Current Zoning: NS HDO (neighborhood services, historic district overlay)
Proposed Zoning: NC(EX) HDO (neighborhood center, exception, historic district overlay)

Approximately 0.517 acres located at the southeast intersection of Cleveland Avenue and East Worthington Avenue, south of East Boulevard.

The petition proposes to allow neighborhood center uses in the existing building on the site in addition to the relocation of the historic Leeper & Wyatt building to the portion of the site that is currently utilized as surface parking.

**RZ1.0**

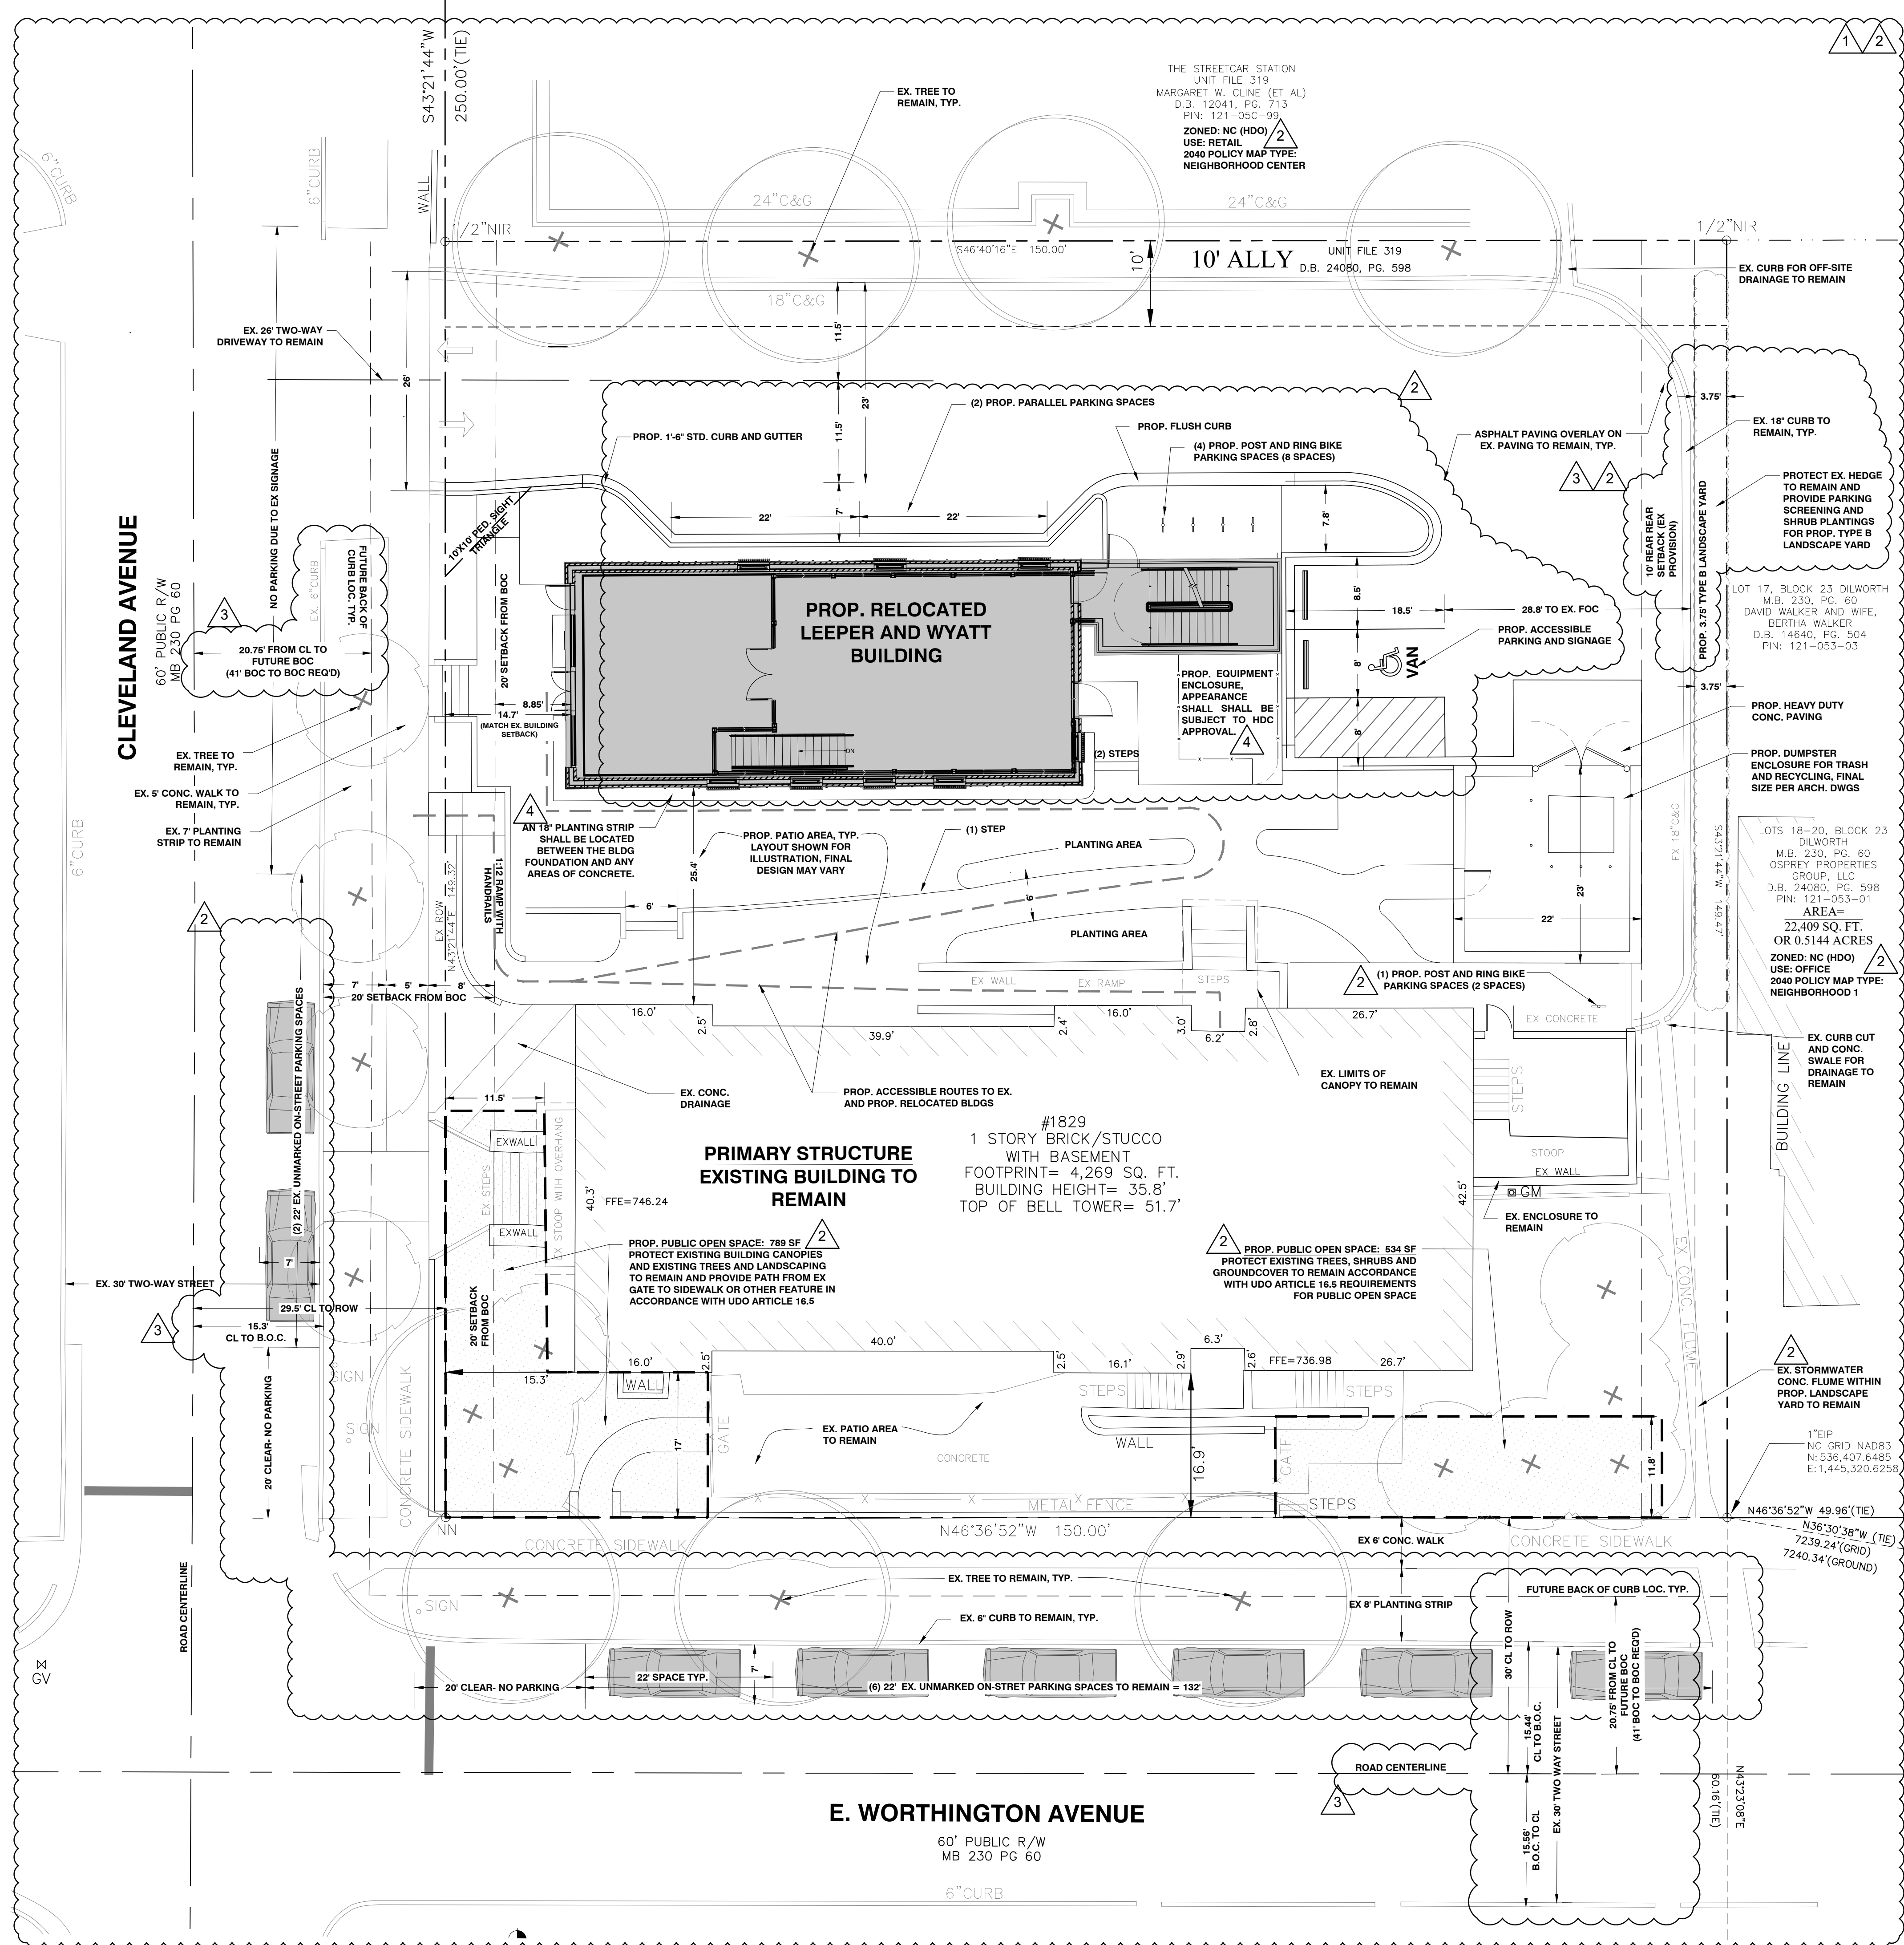
- 1.—Cleveland Avenue and Worthington Avenue are both shown as 30’ wide streets on current site plans. These streets must be at least 41’ wide from back of curb to back of curb per CLDM U-05. Additionally, each road must label and dimension future back of curb location to the centerline. **Addressed**

- 5.—Revise the site plan to show the centerline on each public street. Dimension the right-of-way and the back of curb from the centerline. **Addressed**

- 6.—Update labeling on the site plan to list the setback against the N1 parcel as the rear setback rather than side setback. **Addressed**
- 7.—Update the wording in the parking summary table to clearly distinguish between ordinance requirements, and the various types of parking being provided. The ordinance requires 22 *off-street* spaces for restaurant/bar uses, what is being provided through the EX provision is 4 *off-street* spaces. Separately from that, the proposal includes 8 on-street spaces and 10 off-site leased spaces. Rather than listing out the parking as being in the two categories of on-site and off-site, it should be listed as off-street, on-street, and off-site leased spaces. **Addressed**

- 8.—Consider revising the listed maximum height in the table and the conditional notes to a rounded number rather than listing inches to accommodate unforeseen circumstances or errors in the height measurements for the historic building. **Addressed**

- 9.—Update the conditional notes for the EX provision regarding parking to clearly state that the ordinance requirement is for 22 *off-street* spaces, and the proposal is to provide 4 *off-street* spaces. Remove references to the on-street and leased spaces from this conditional note in the EX section and move that language regarding the other parking to a separate section that details the three types of parking spaces being provided. **Addressed**
